22nd October 2026

Kent and Essex Inshore Fisheries and Conservation Authority
Paragon House
Albert Street
Ramsgate
Kent
CT11 9HD

Sea Link Project (EN020026) - Comments on the Applicant's responses to the Secretary of State's requests for information

Plate 2.1 New sediment release locations at landfall approaches (circled in yellow)

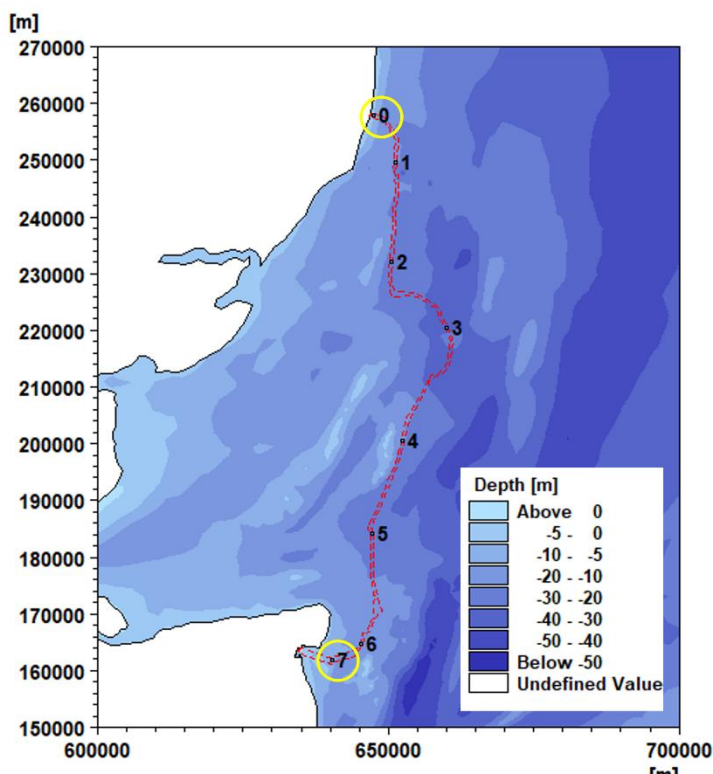
13. KEIFCA acknowledges that the Applicant has modelled sediment dispersion for both ploughing and jetting scenarios and assessed effects on shellfish in Document 6.2.4.3(B), paragraphs 3.9.54-3.9.60. Paragraph 3.9.58 reports modelled fine-sand suspended sediment concentrations of 100 mg/l at distances of up to 11 km, associated with resuspension at multiple locations rather than a single continuous plume. This does not establish adverse effects at cockle beds within the identified outer Thames management areas. However, KEIFCA requests that the Applicant identify the relevant modelling outputs and explain the predicted concentrations, exposure durations and deposition at these beds. The response should explain how the sensitivity of cockles, including relevant life stages, supports the conclusion of negligible effects, rather than relying solely on general statements about shellfish mobility or tolerance of suspended sediment. Where the existing assessment does not adequately resolve these matters, supplementary assessment should be provided.

Figure showing Offshore Scheme (red) and subtidal chalk habitat (green)

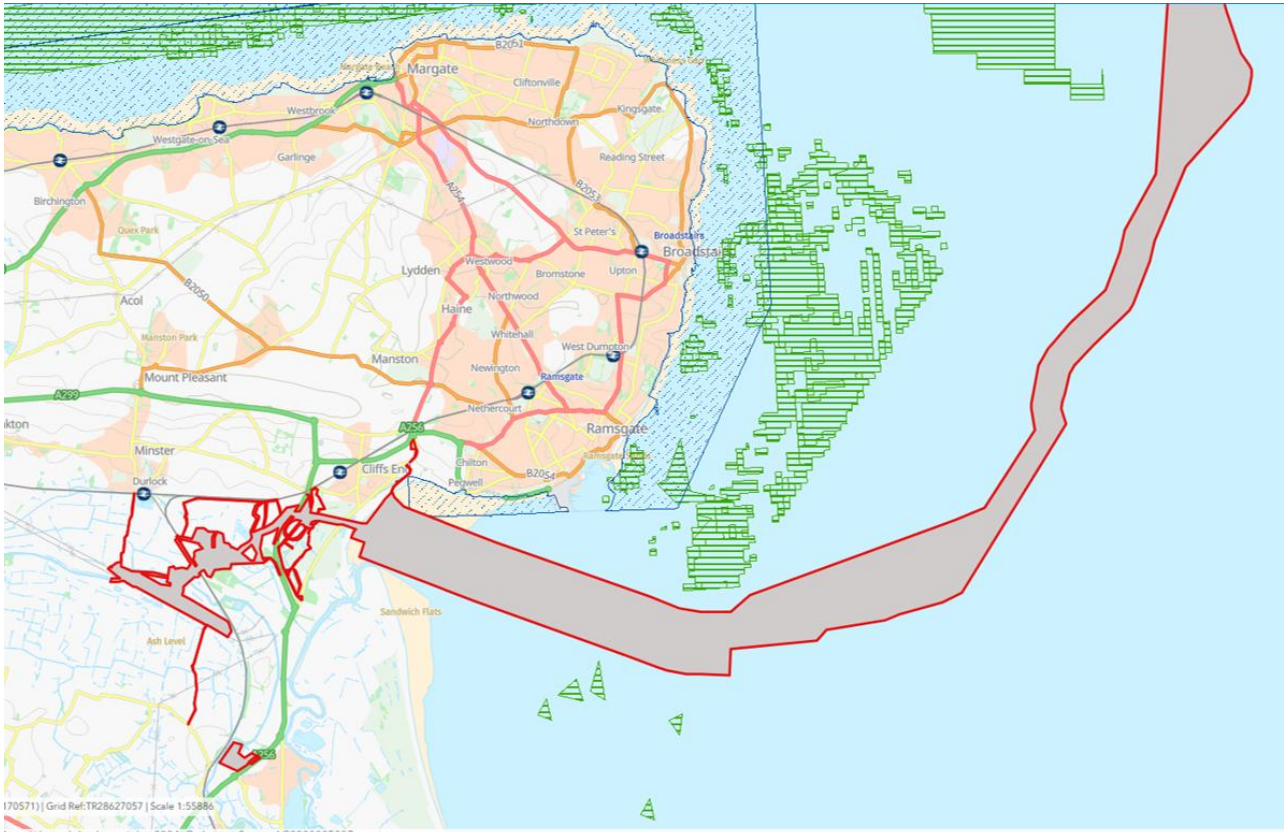
1. Kent and Essex Inshore Fisheries and Conservation Authority (KEIFCA) welcomes the opportunity to comment on the Applicant's further submissions, particularly the response to fisheries matters in Document 9.159 [C3-002], Table 1.2, page 25 (Paragraph 9), as well as to the updated Register of Environmental Actions and Commitments (REAC, Rev H), Outline Offshore Construction Environmental Management Plan (CEMP, Rev G) and Outline Cable Specification and Installation Plan (CSIP, Rev E) published on 19 October 2026. This response should be read alongside KEIFCA's submission dated 18 September 2026 concerning paragraph 9 of the Secretary of State's request for information.
